Memorandum

Exhibit 16

To: Ryan Harriman
From: Ruji Ding
Re: SUB21-002
Date: September 20, 2022

I've reviewed the submittal package and have the following conditions of approval:

4001 WEST MERCER WAY SHORT PLAT  
SHORT PLAT MAP

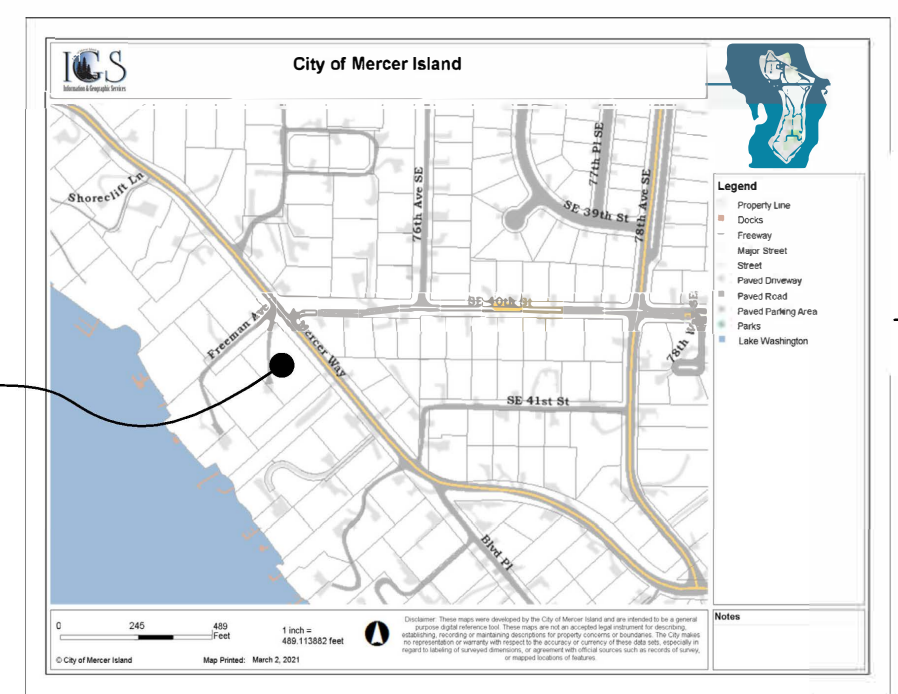
4. A City of Mercer Island title block for approval signatures (Planner and City Engineer) shall be provided on the final plat along with the designated Short plat number.

4001 WEST MERCER WAY SHORT PLAT  
SHORT PLAT MAP

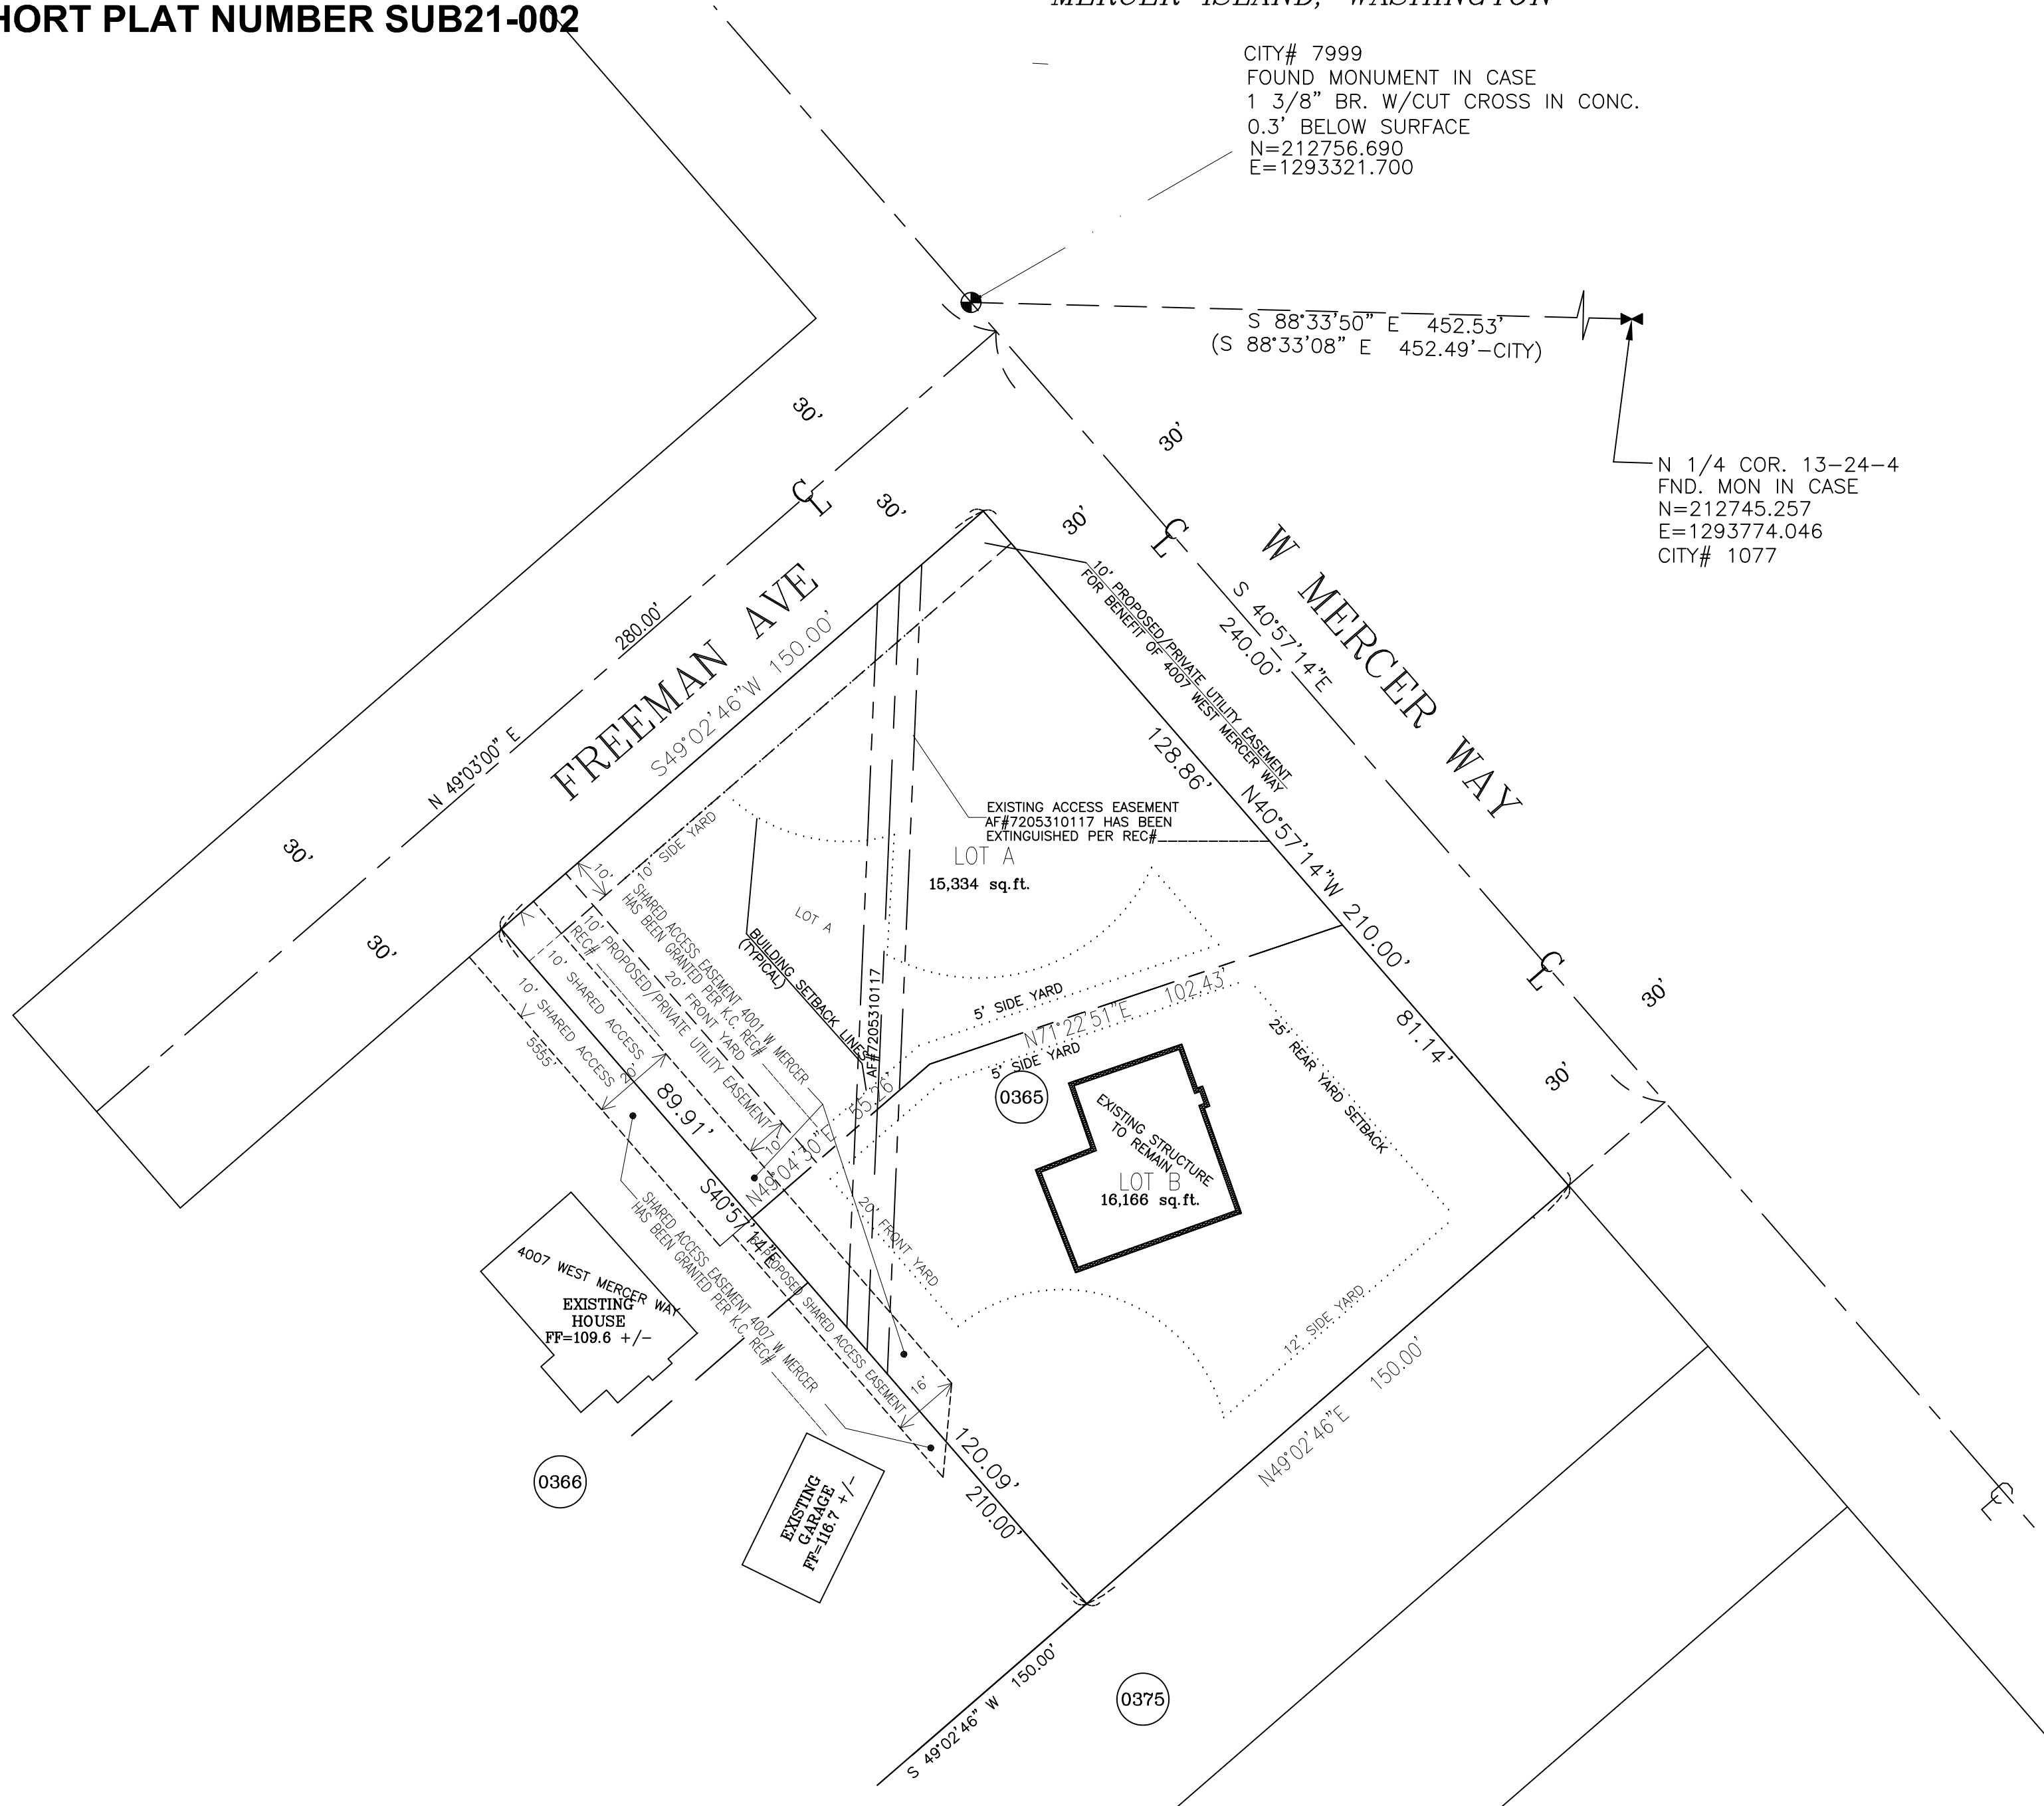
1. Show all the existing and proposed easements on the final plat. Clearly distinguish all public easements from the private easements. The private utility easement and public utility easement shall not be combined.

2. Easements for utilities and storm drainage facilities shall be depicted on the face of the Final Plat. Language which indicates joint rights and responsibilities of each lot with respect to all utilities and roadways shall be shown along with individual lot Joint Maintenance Easement Agreements (where applicable) for all shared usage and filed with the King County Recorder and noted on the final plat. The easement notation shall indicate whether the easement is public or private, existing or proposed.

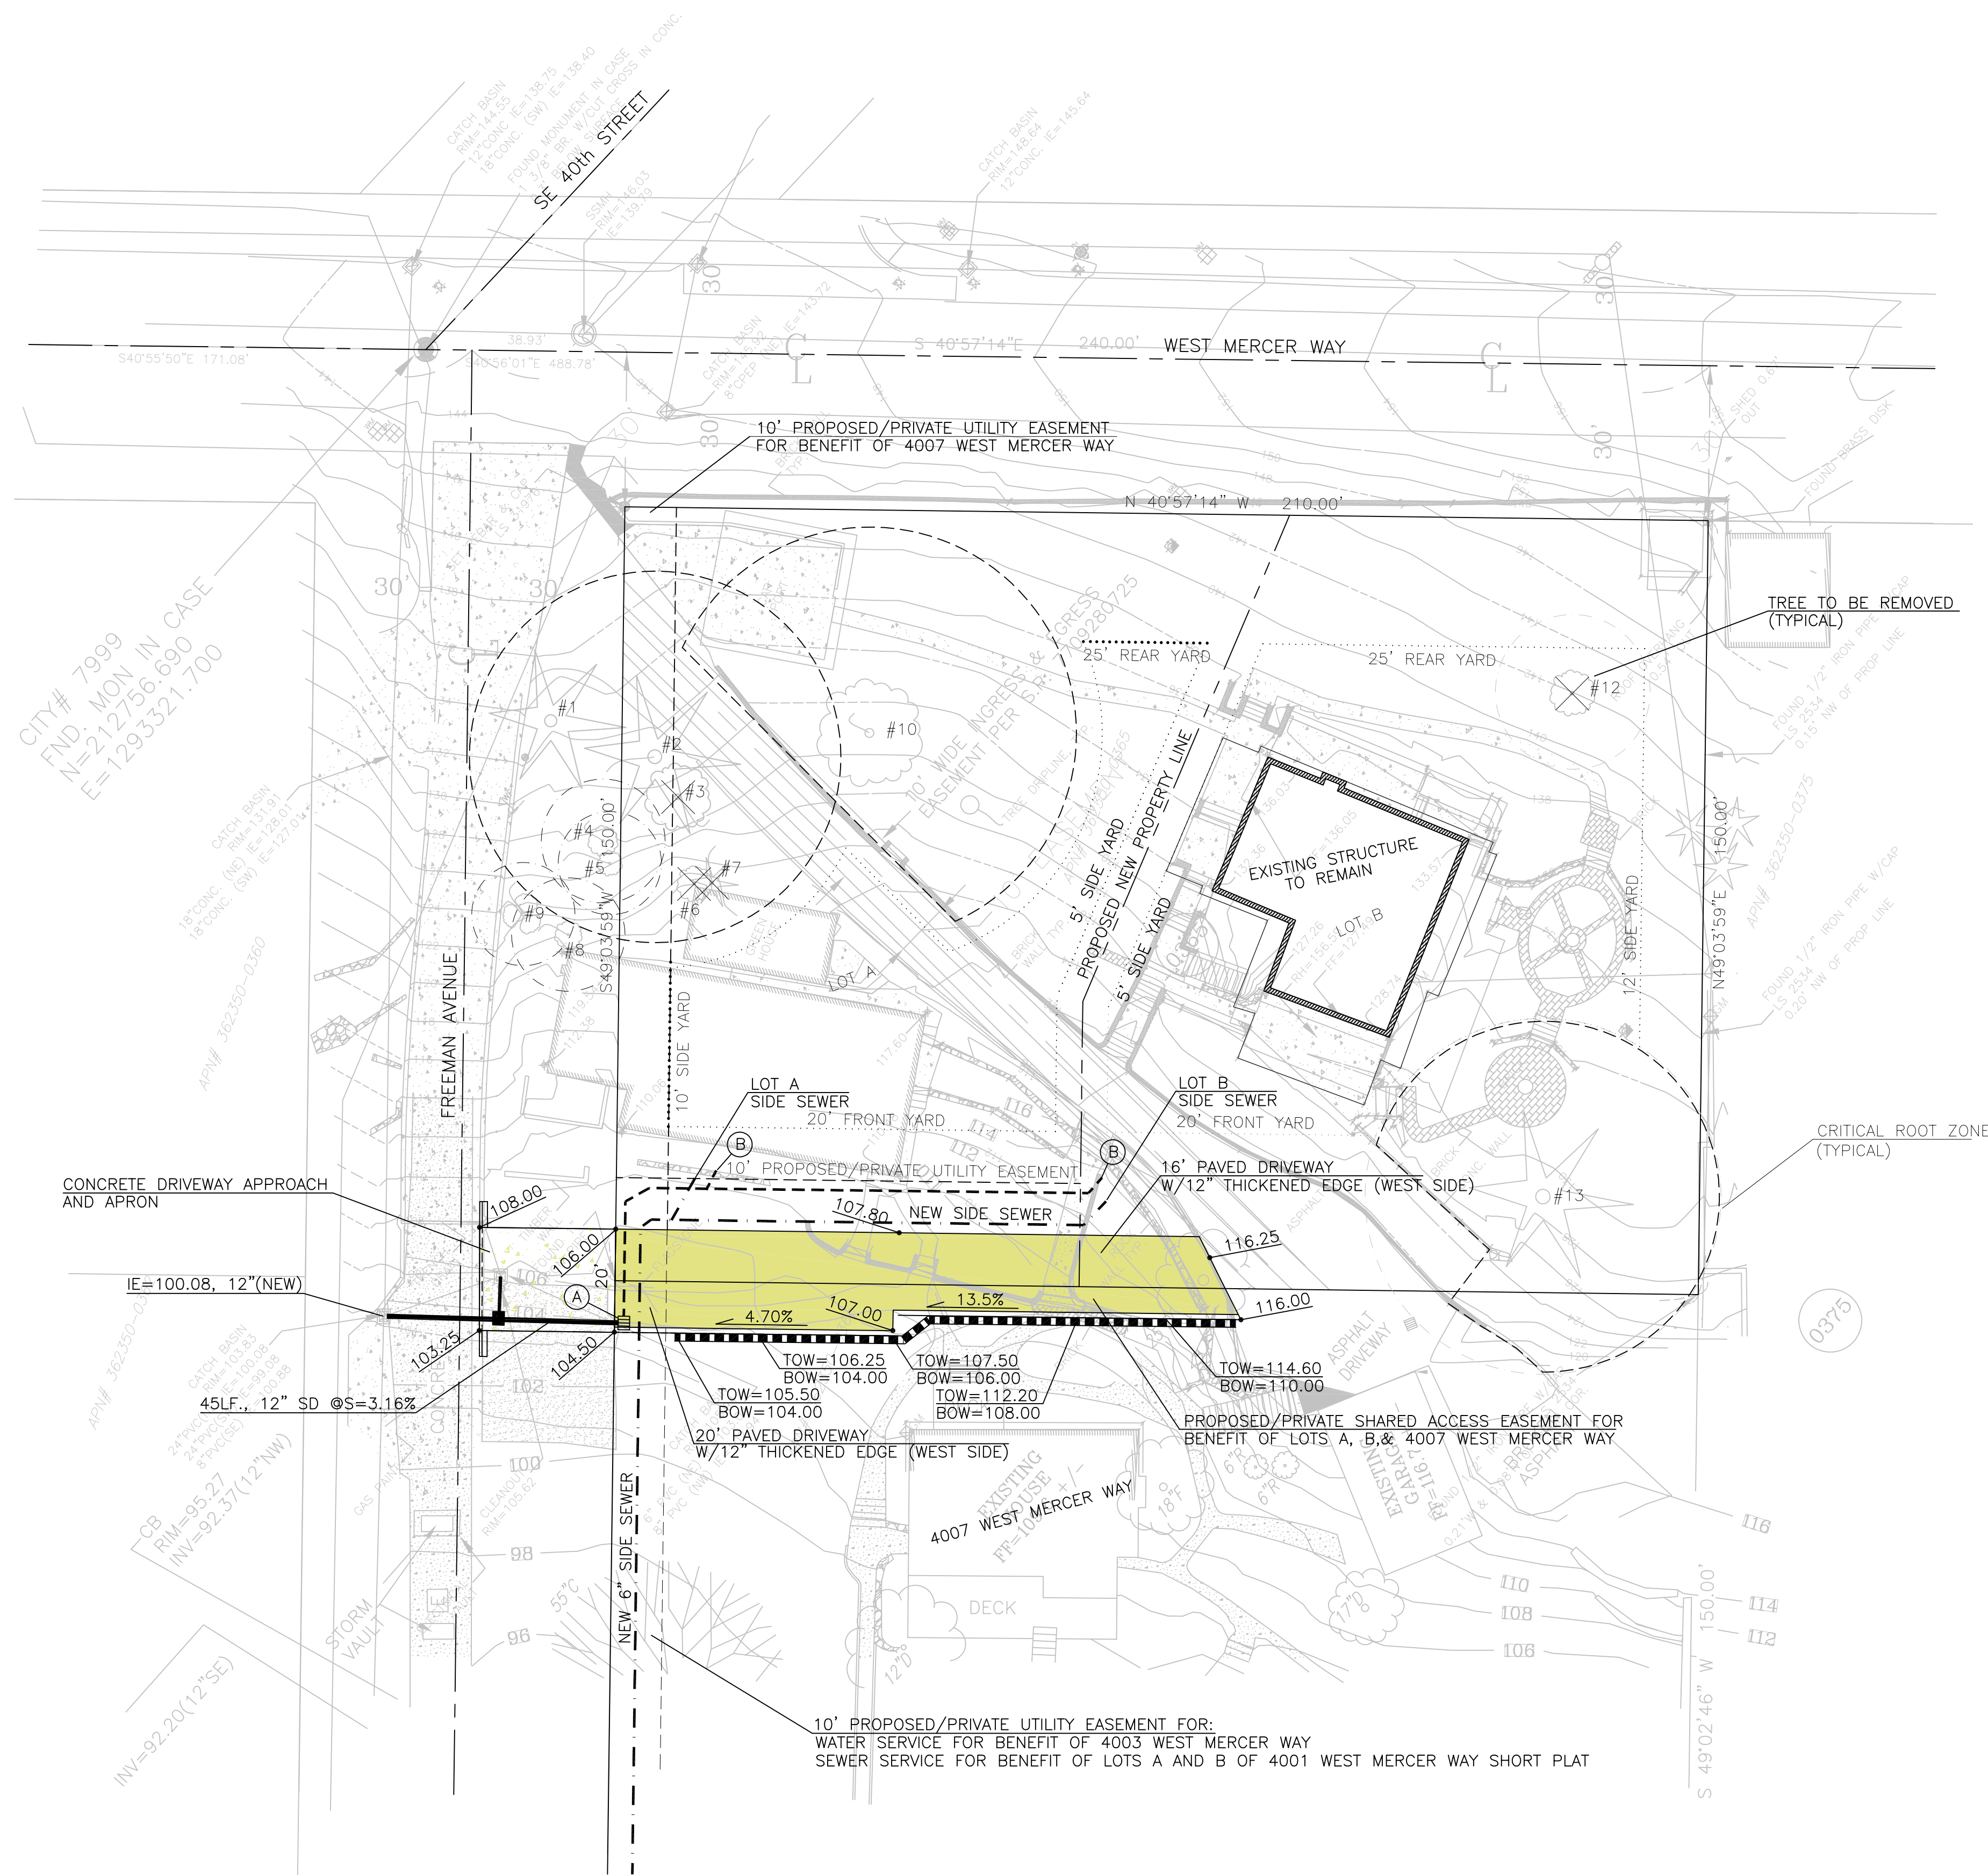
6. The private shared access between 4001 W. Mercer Way and 4007 W. Mercer Way shall be completed prior to plat recording. A Site Development Permit for constructing the shared access and the storm drainage system associated with the private shared

access are required for the city approval. A construction bond (150% of the construction cost) for the shared access and storm drainage system associated with the shared access are required prior to issuance of the permit. All construction must be completed prior to submit the final plat.
